# CITY OF ALBUQUERQUE

April 8, 2022

**Re: Lot 22 Meridian Business Park  
541 Silver Creek Rd. NW  
30-Day Temporary Certificate of Occupancy  
Transportation Development Final Inspection  
Engineer's Stamp dated 7-20-20 (K10-D0231)  
Certification dated 3-31-22**

ENGINEER'S SEAL RONALD R. BOHANNAN P.E. #7888	MERIDIAN BUSINESS PARK ALBUQUERQUE, NM LOT 22 TRAFFIC CIRCULATION PLAN	DRAWN BY pm
		DATE 7-20-2020
TERRA WEST, LLC 5571 MIDWAY PARK PL NE ALBUQUERQUE, NEW MEXICO 87109 (505) 858-3100 www.tierrowestllc.com	SHEET # SP-1	DRAWING 2020033-SP
		JOB # 2020033

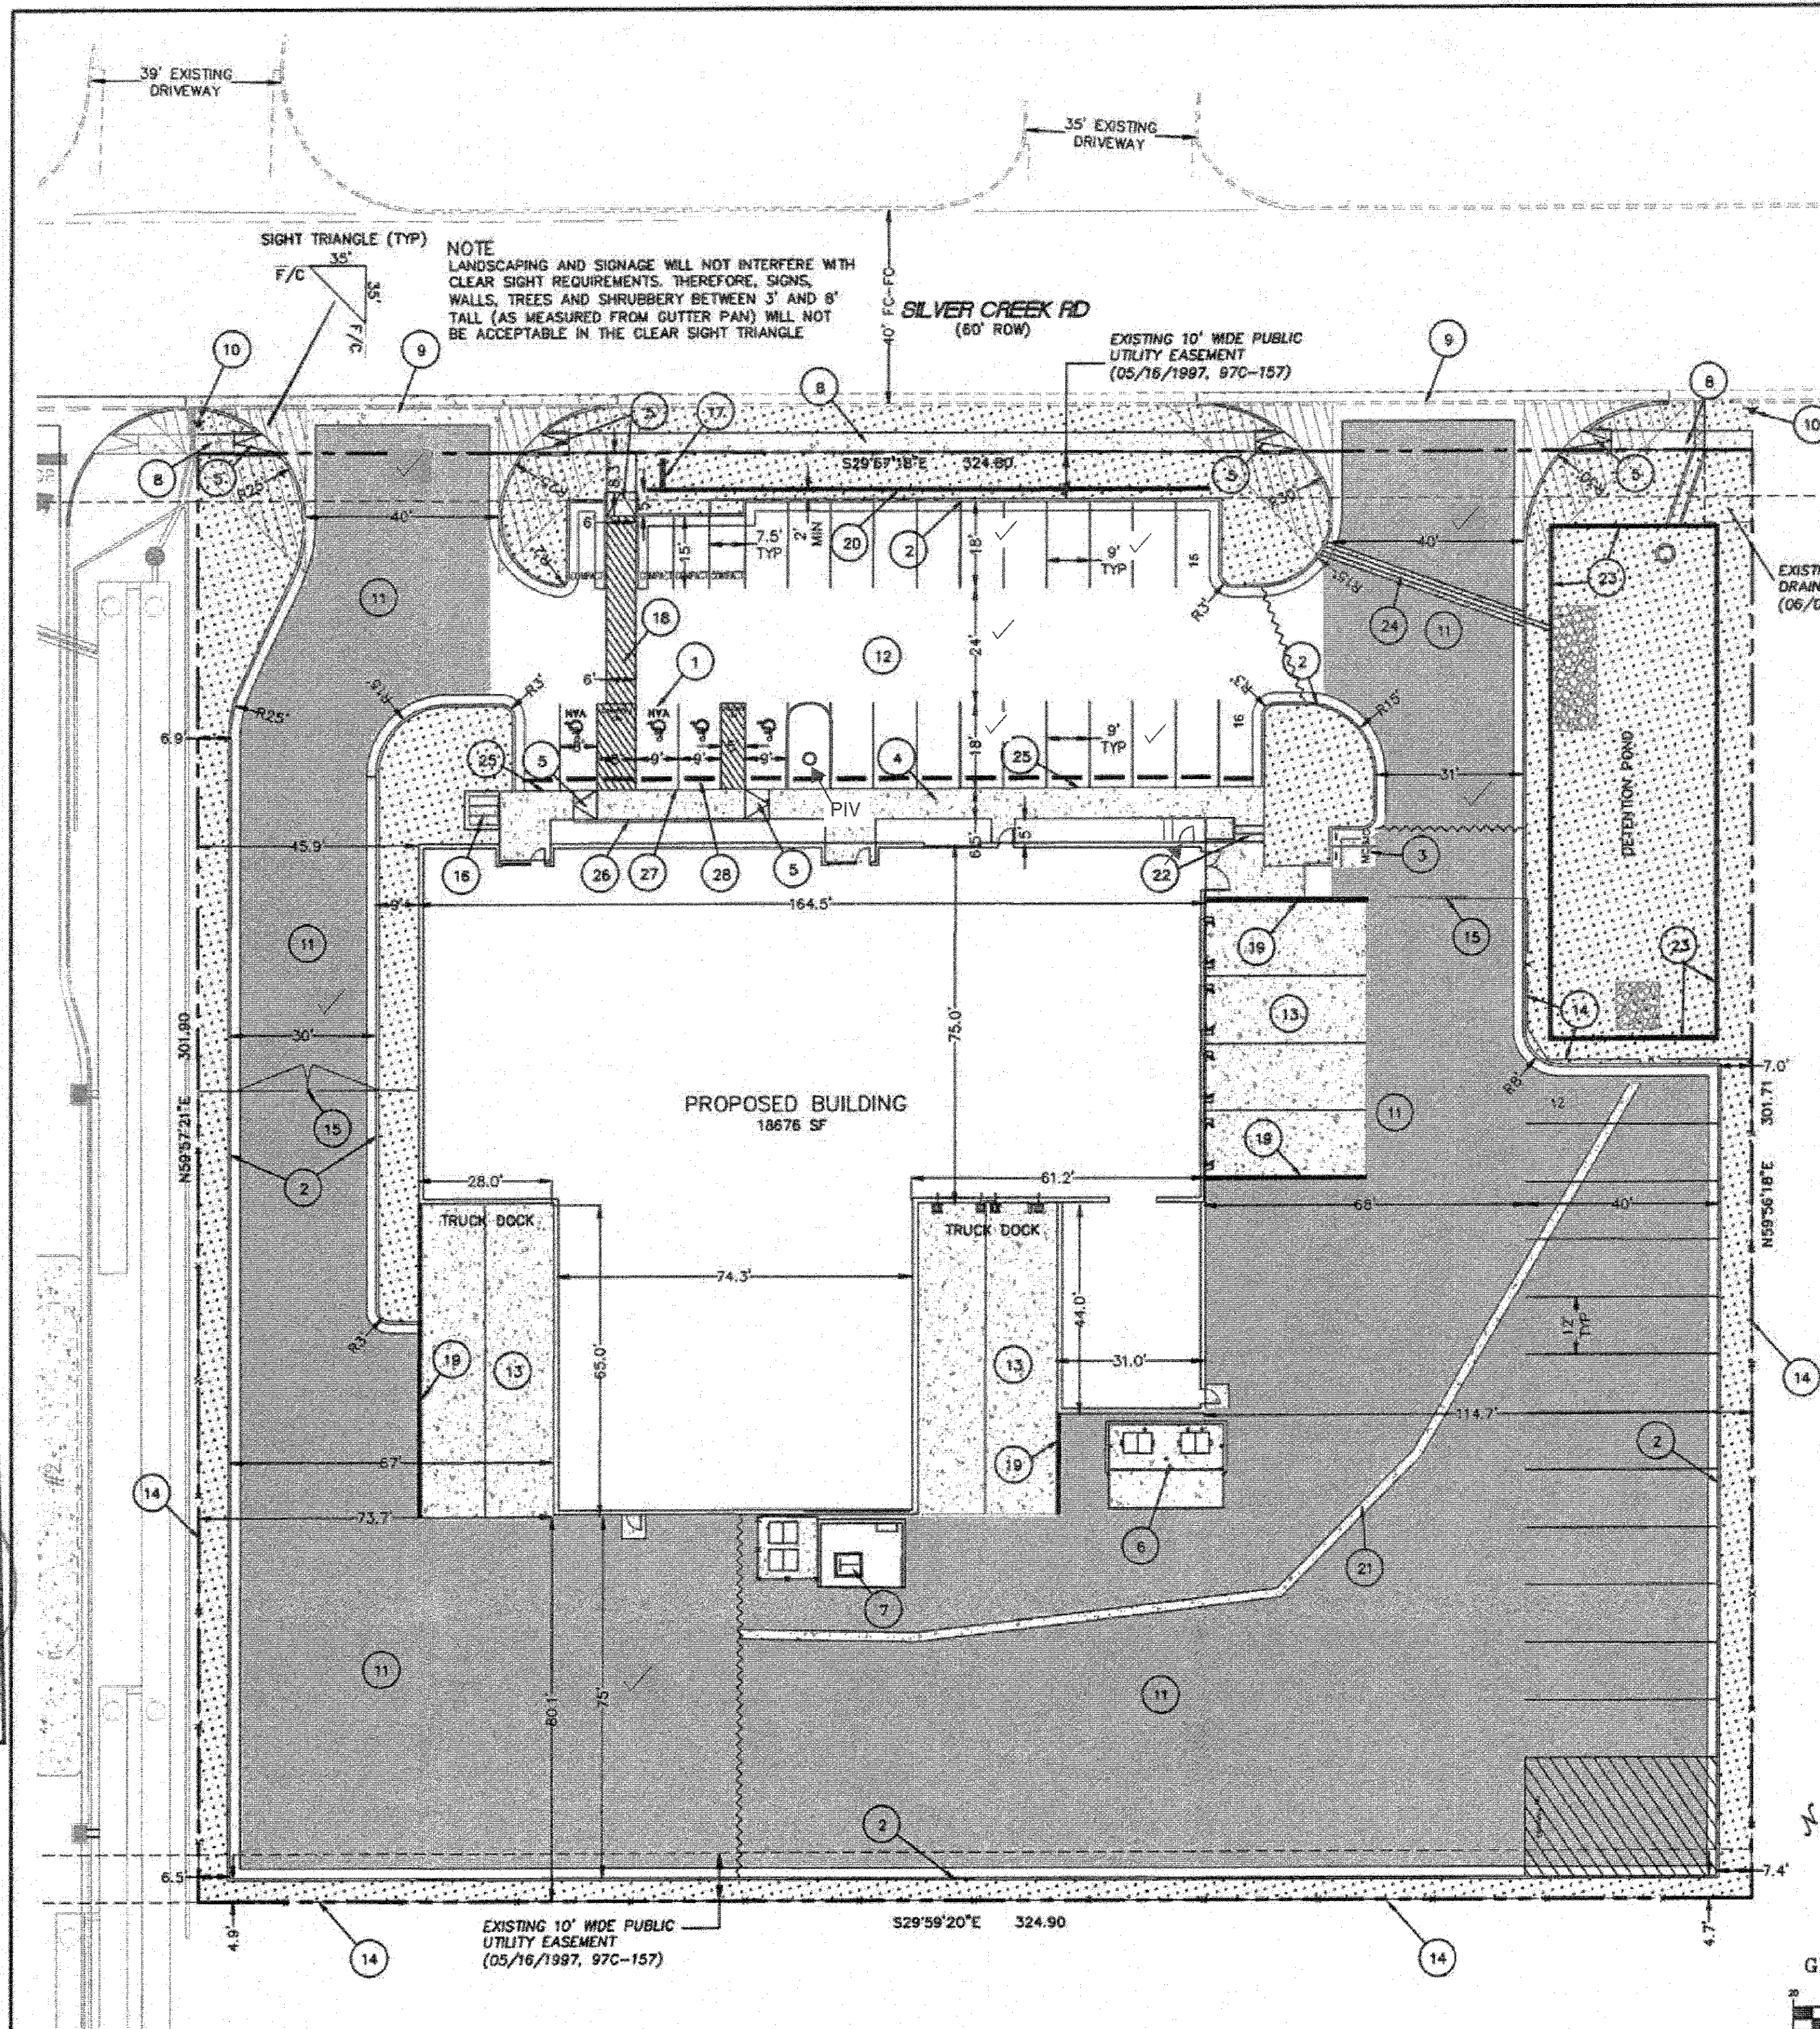
- **The cross slope** for the northwest leg of the driveway entrance is 4.6% to 3.5%, and it should be 2%max. Please fix it.
- Label the parking stall on the Westside of the pedestrian pathway by placing the word "COMPACT" on the pavement.
